Application for a non-material amendment following a grant of planning permission. Town and Country Planning Act 1990

ERCTION OF OUTBUILDING TO USE AS GYM/SNOOKER ROOM WITH SHOWER ROOM

17796/APP/2021/3247

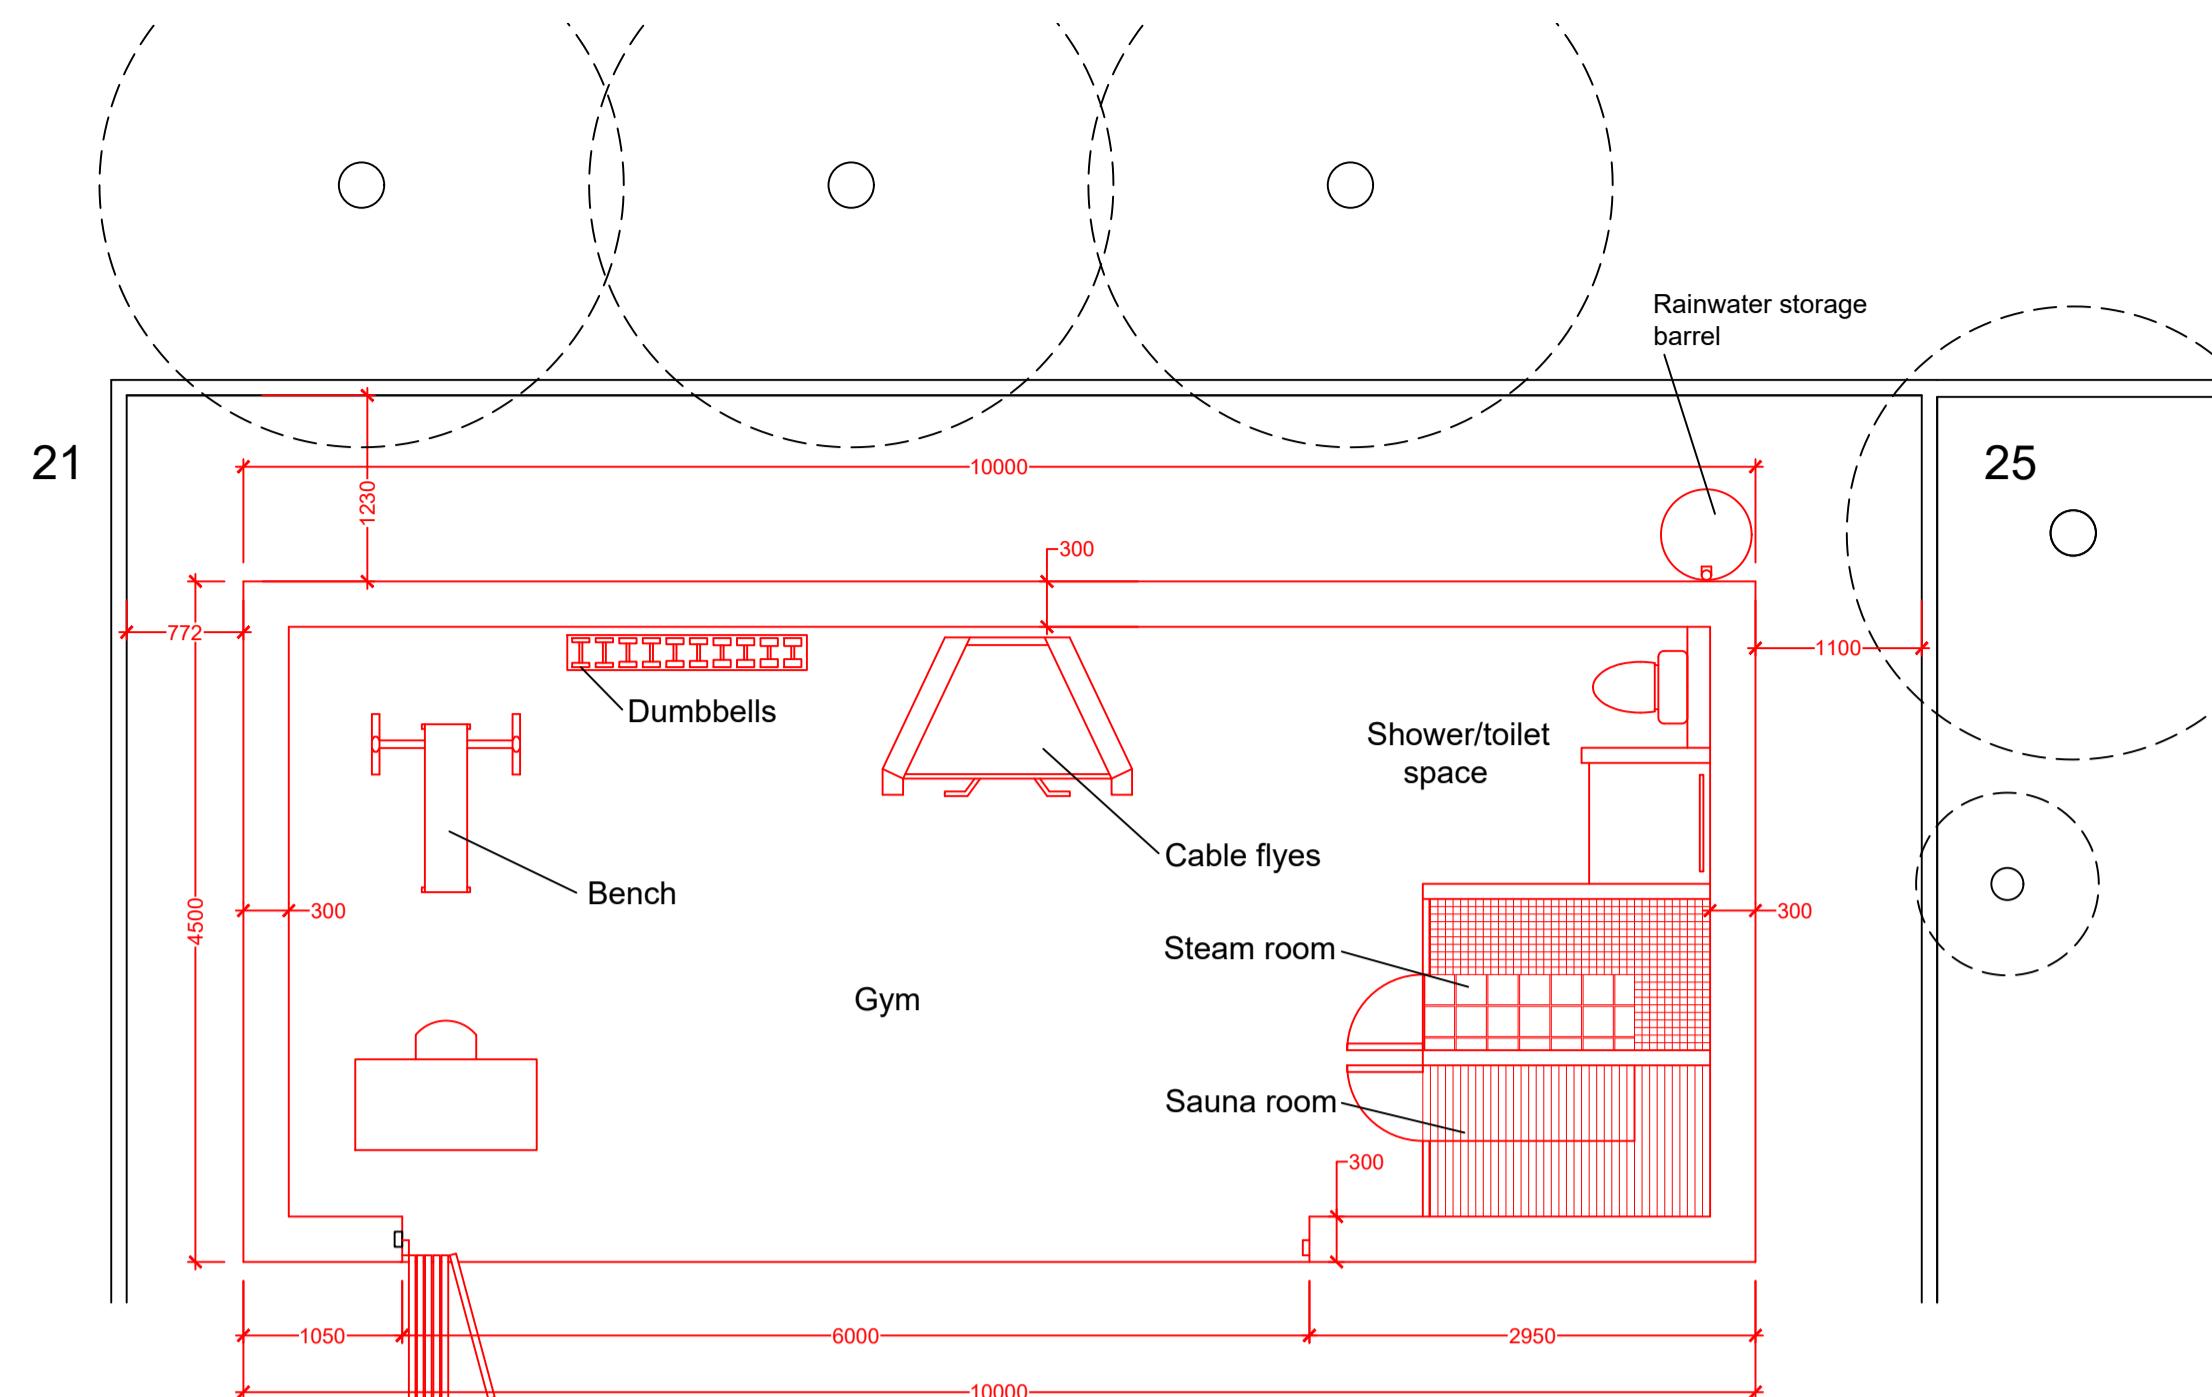
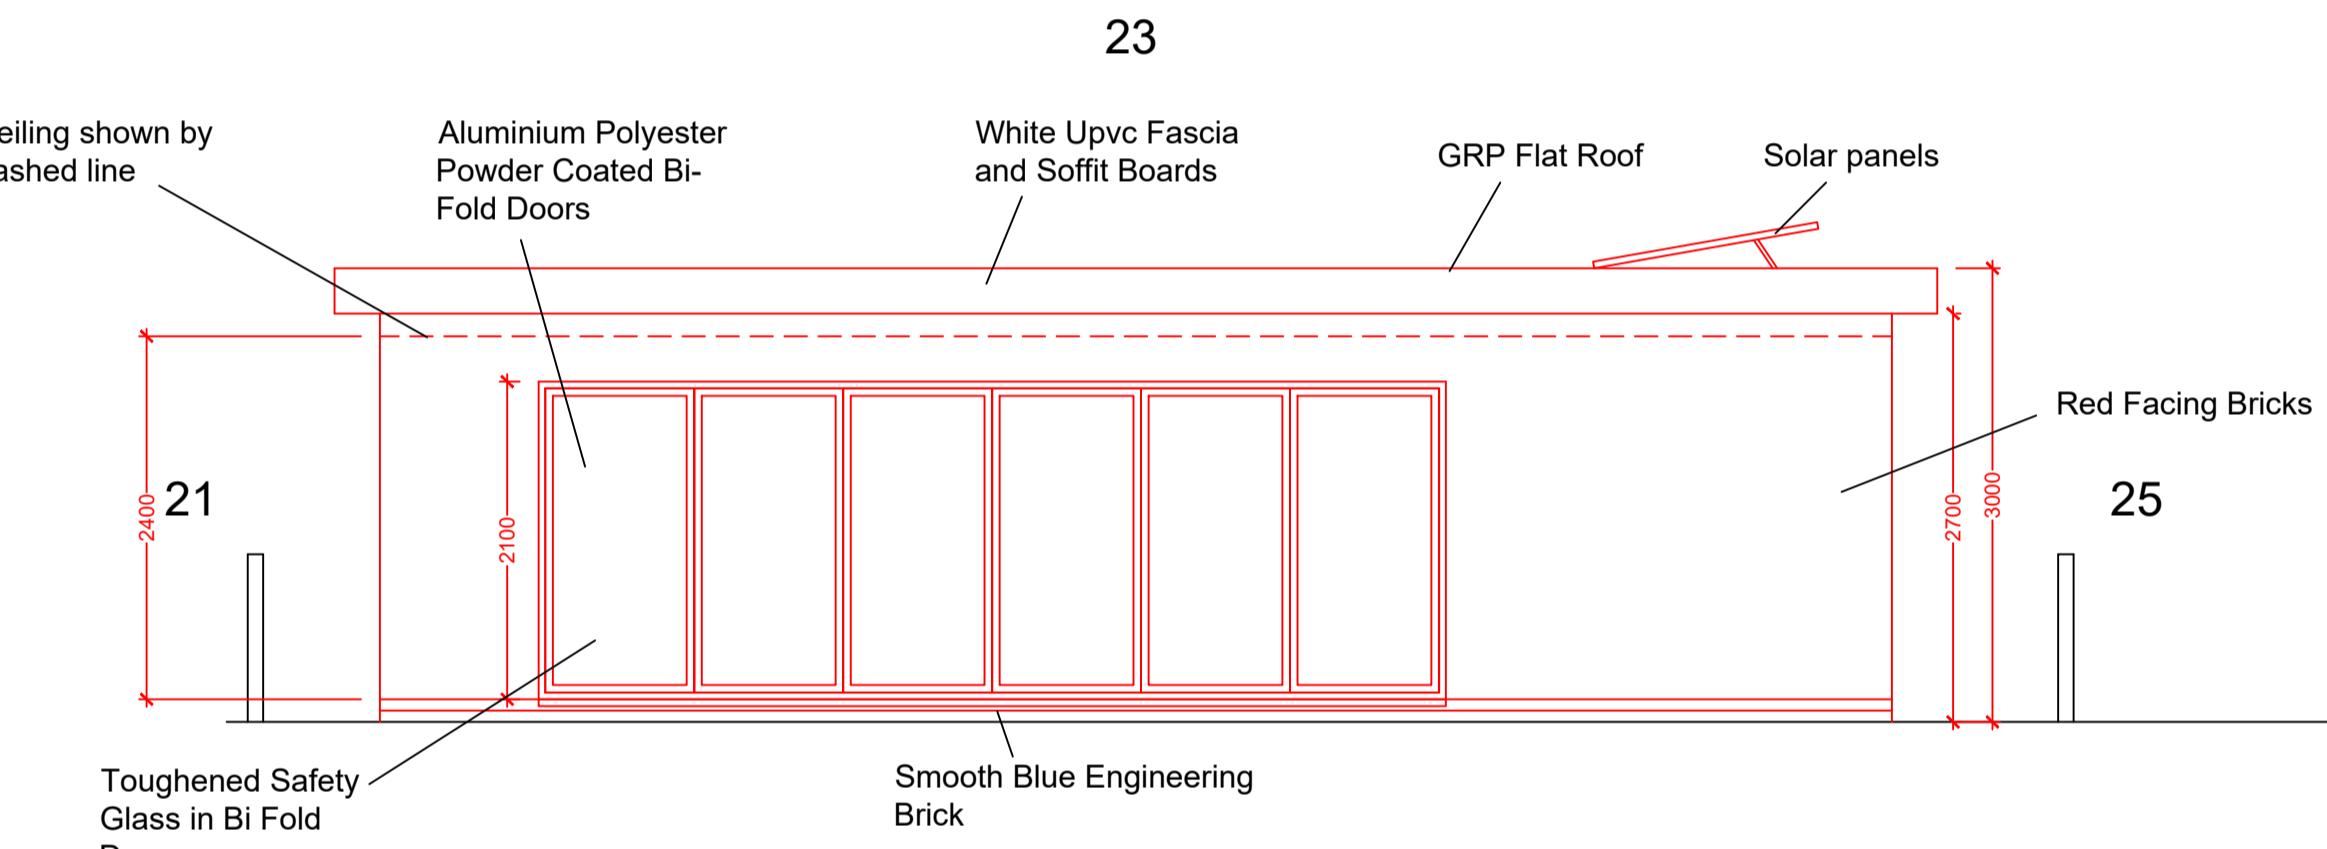
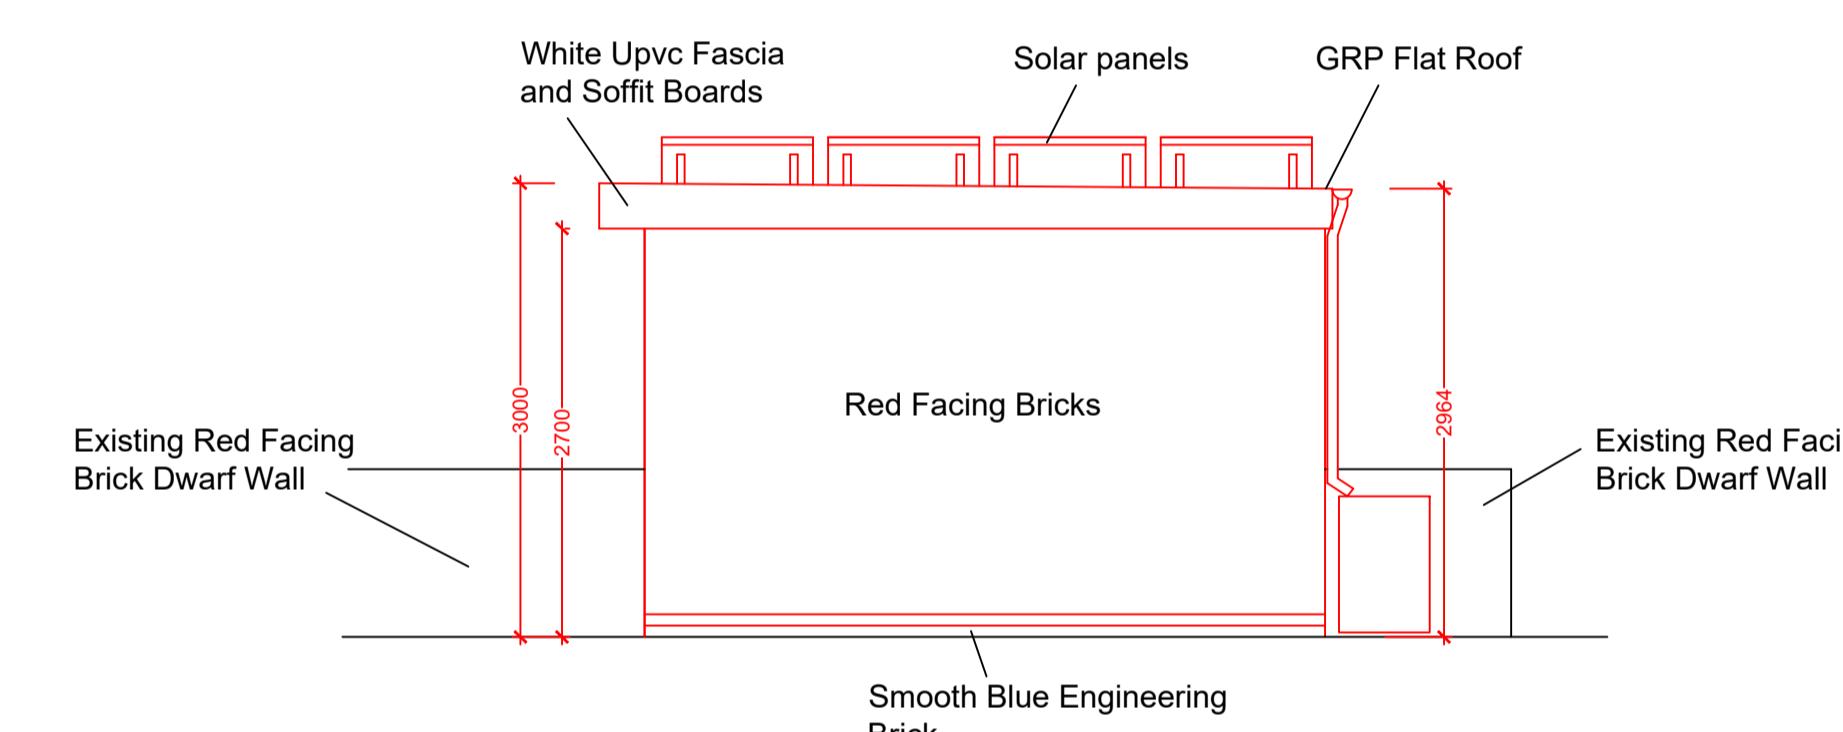
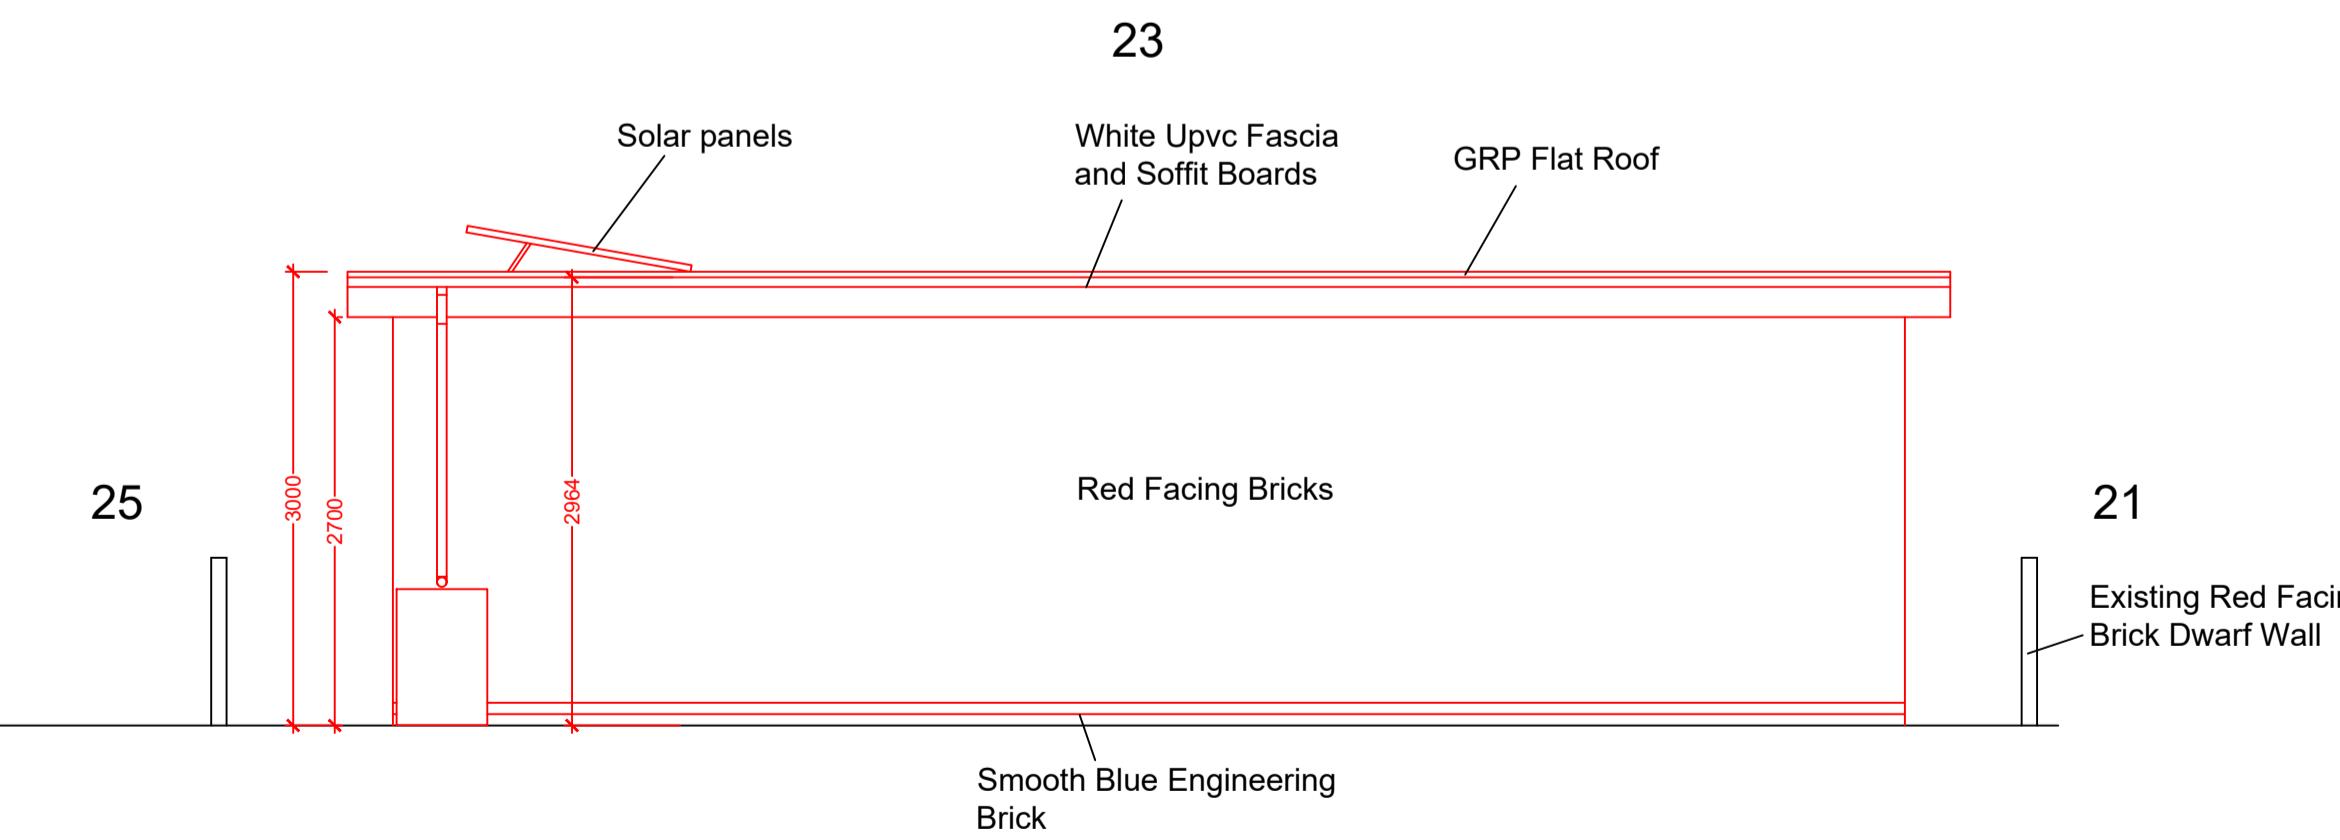
ROOF PRO[REDACTED], ROOF HEIGHT REDUCED, FRONT WINDOW REMOVED, SAUNA AND STEAM ROOM ADDED TO INTERIOR.
